# DEMETRIOU

July 31, 2017

**RE: ADU17-003, CAO1-005, DEV17-009, SHL1-007, SUB17-004 First Review Letter  
Land Use Applications for proposed home, ADU, driveway and retaining wall  
construction within a steep slope along the shoreline for the Lady Bug Trust**

RICHARD A. TOMKINS, PE
PROJECT MANAGER
MARY MCDOWELL, PLS
PROJECT SURVEYOR
ADAM STRICKER, PE
PROJECT ENGINEER

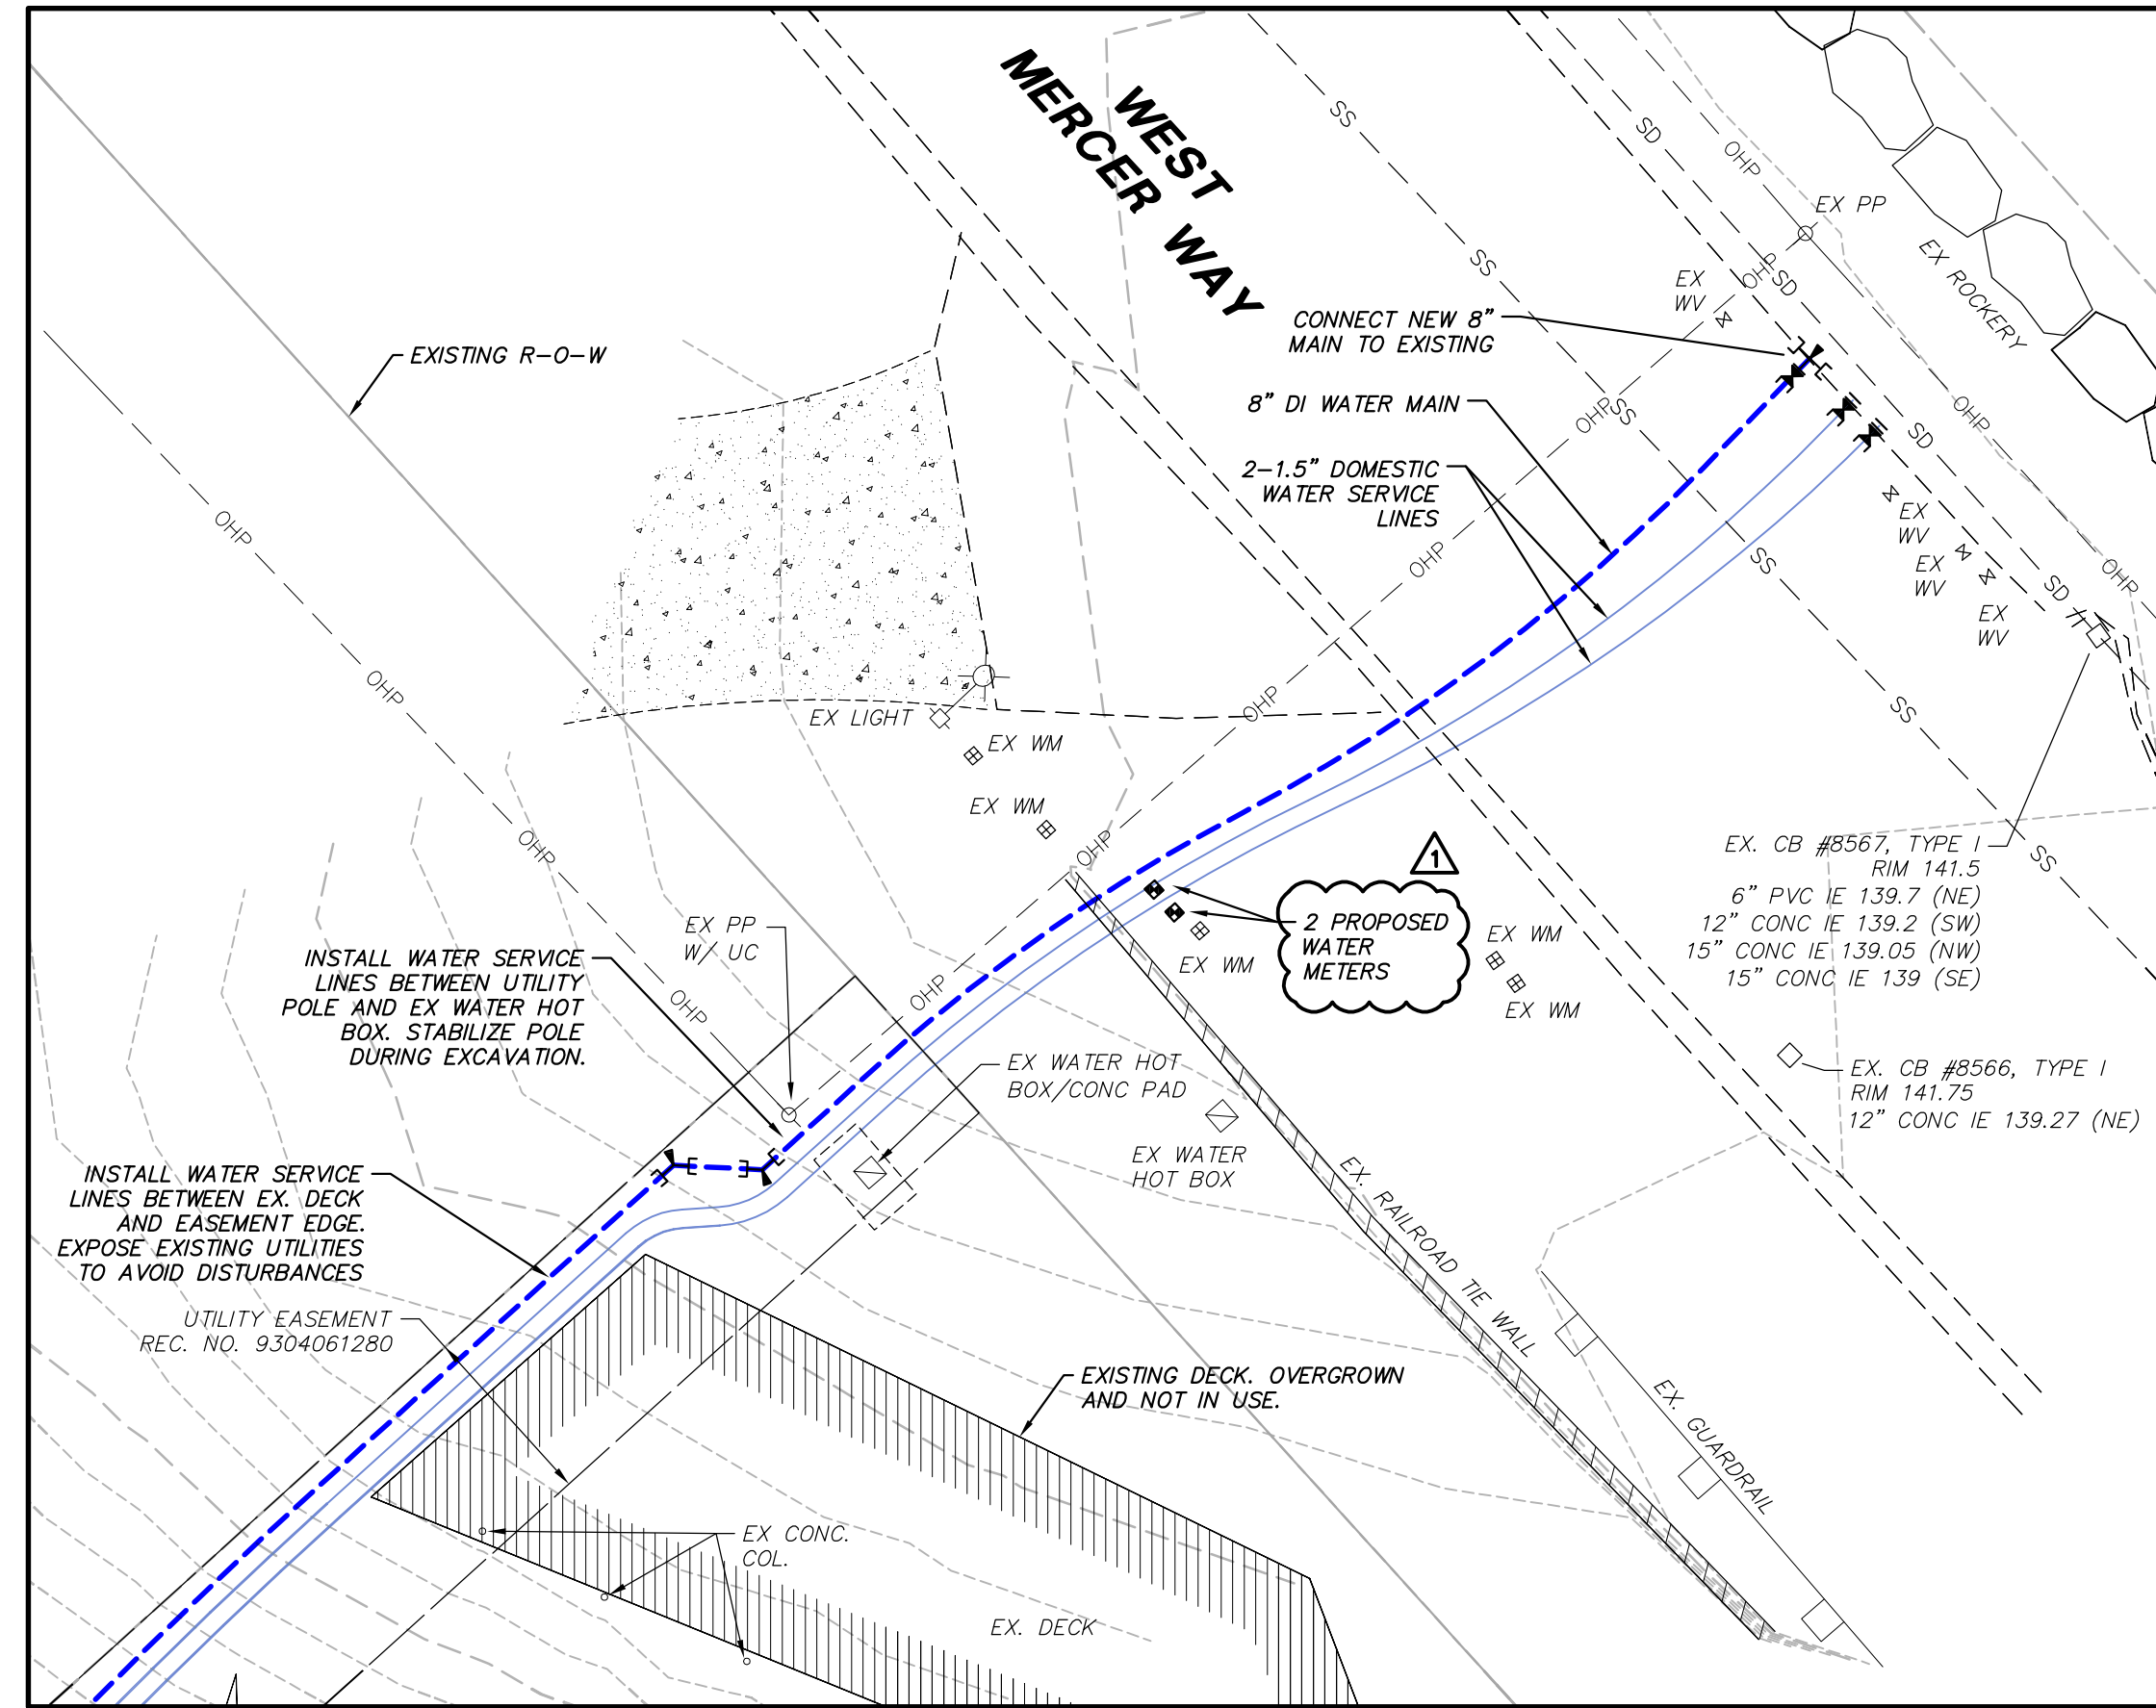
11. *Please provide a profile of the entire proposed access road on Lot 1 and including onto Lot 2. Please note that the driveway slope can't exceed 20%.*

**A profile of the proposed driveway is now shown on C2. The design has a maximum slope of 18% and uses a vertical curve transition at the base. There will be a relatively flat access to lot 2 past the initial steep section.**

CONCEPTUAL GRADING AND UTILITY PLAN
WITH CRITICAL SLOPES

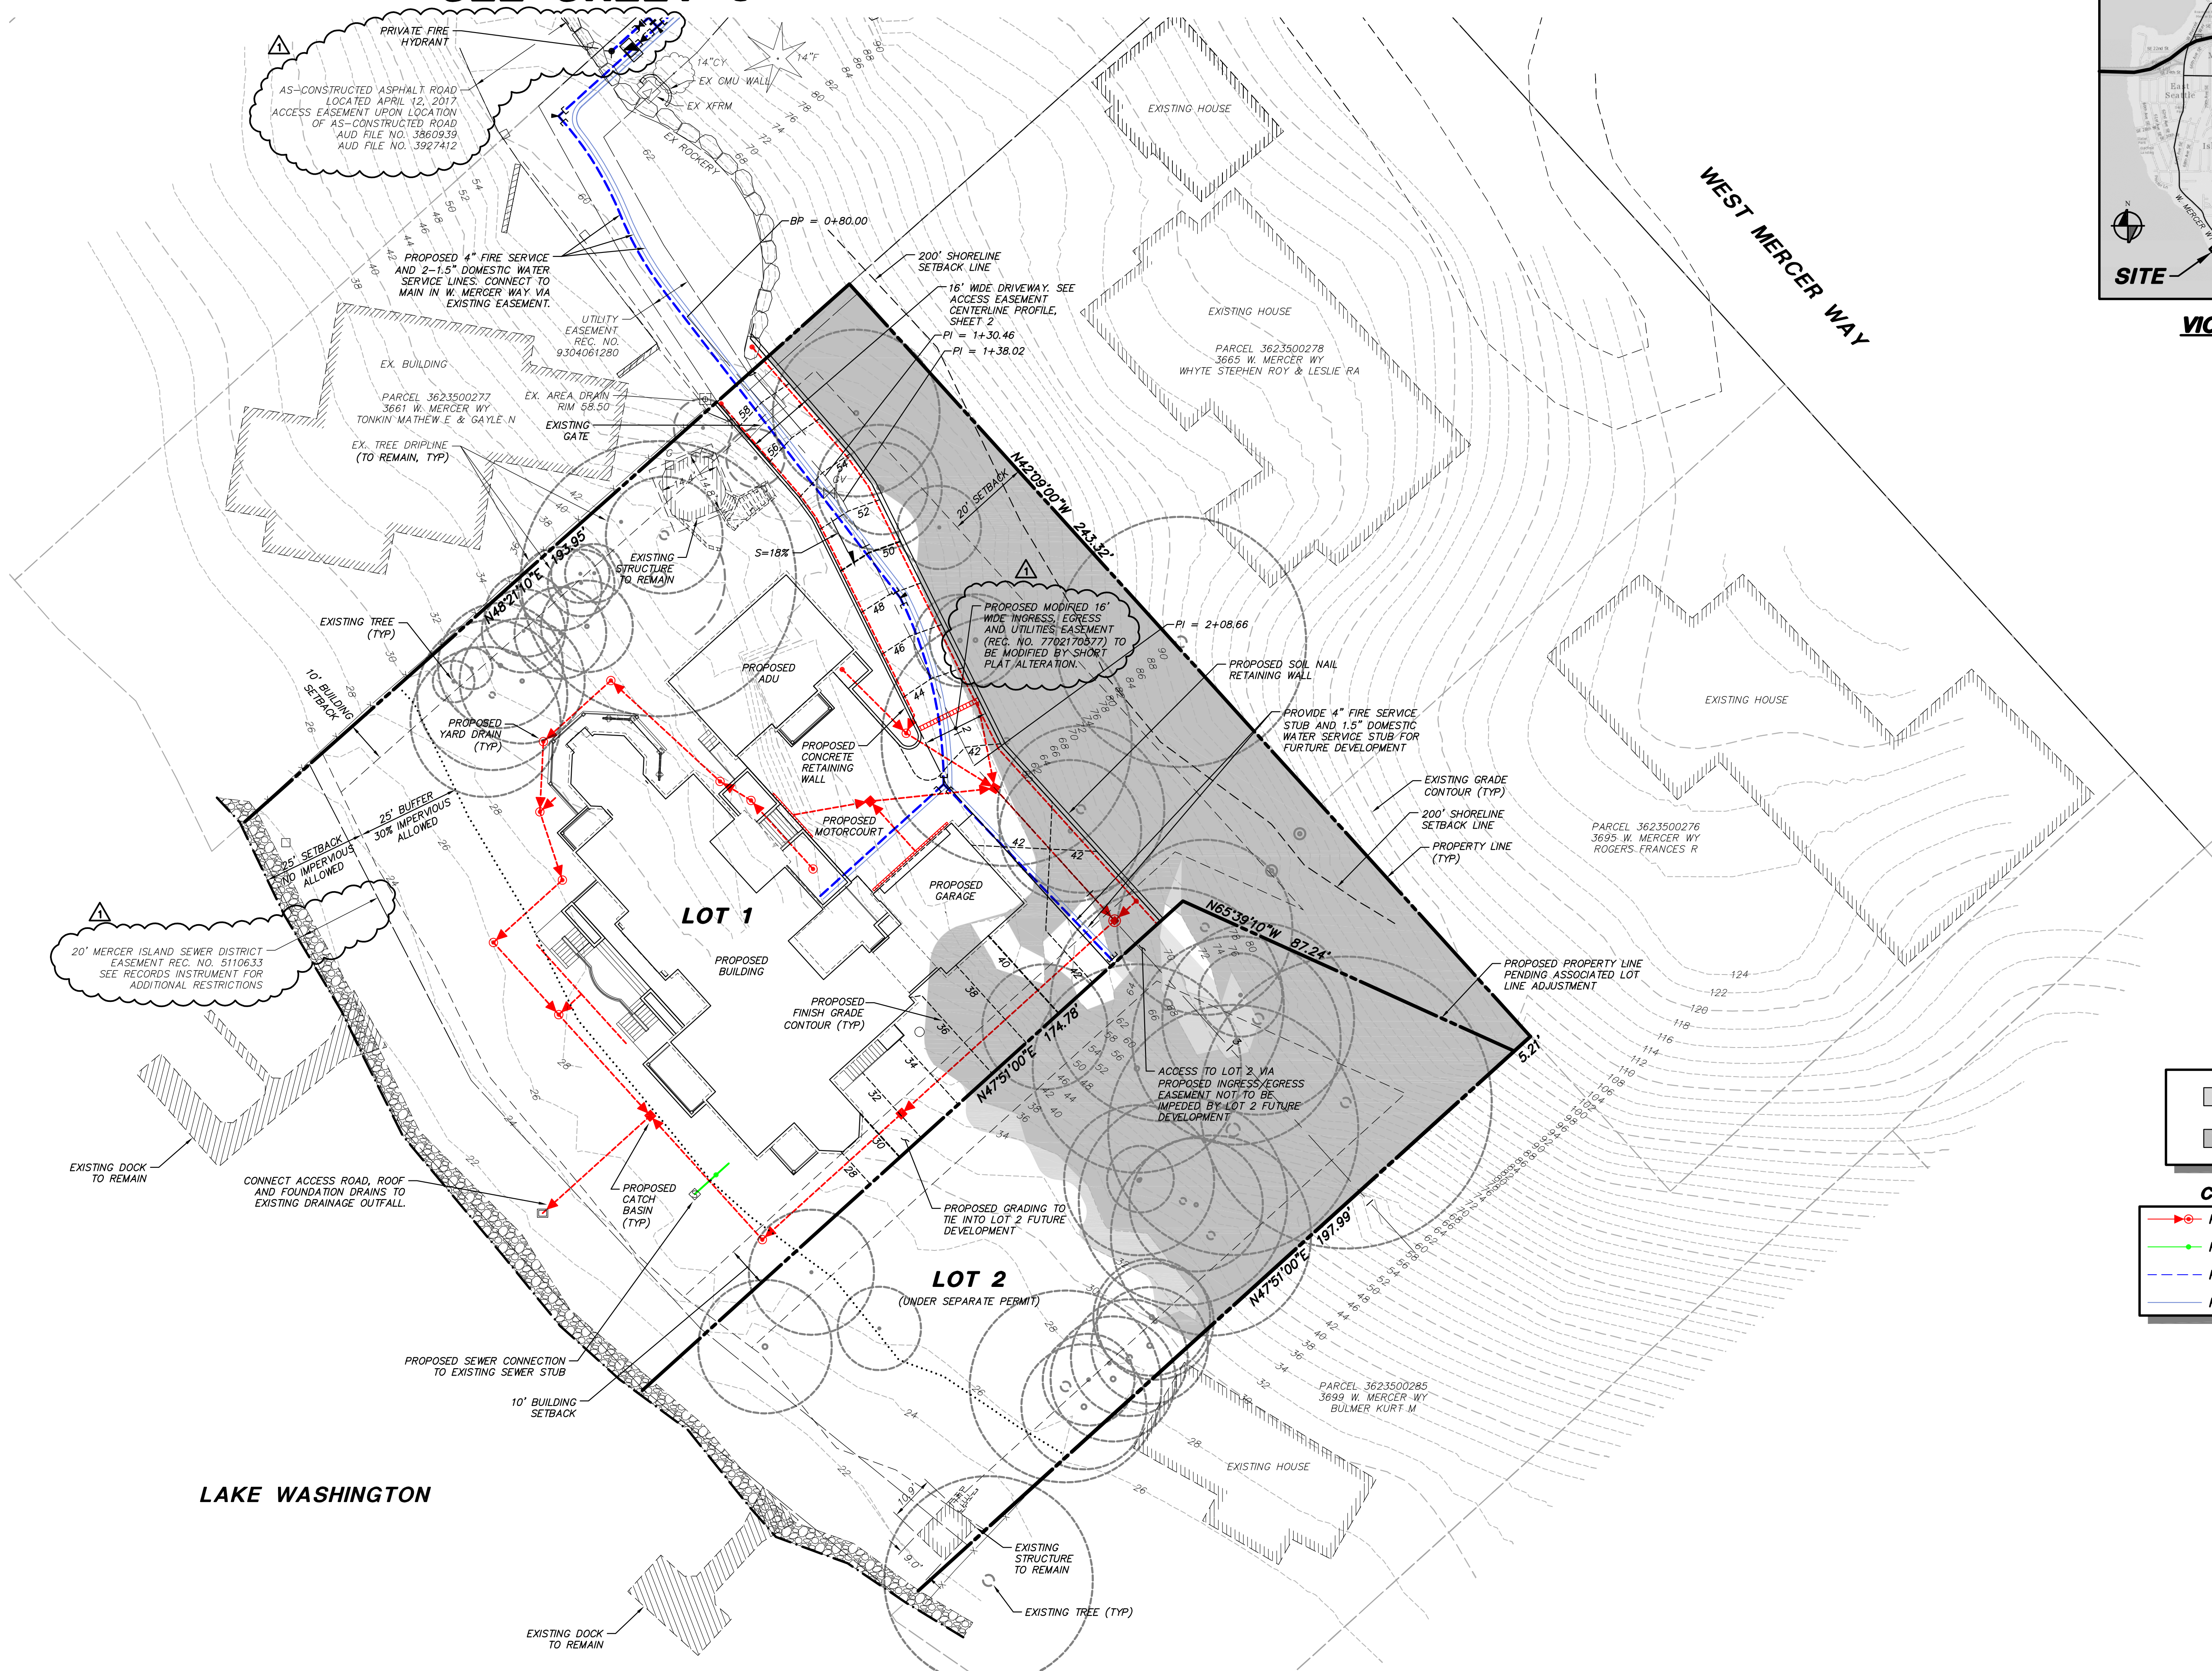
9. *A fire hydrant will be required for the new home.*

**A possible location for a new fire hydrant has been shown on the attached Conceptual Grading and Utility Plan. The property has a utility easement which runs up the hill (and not along the private access road to the site). Opportunities for locating a fire hydrant**

will have to be within this easement which restricts fire hydrant placement to the location shown which would put the hydrant at the top of a ~4' high rockery. Alternate locations could be at the midpoint of the access road which would put the fire hydrant significantly further from the project.
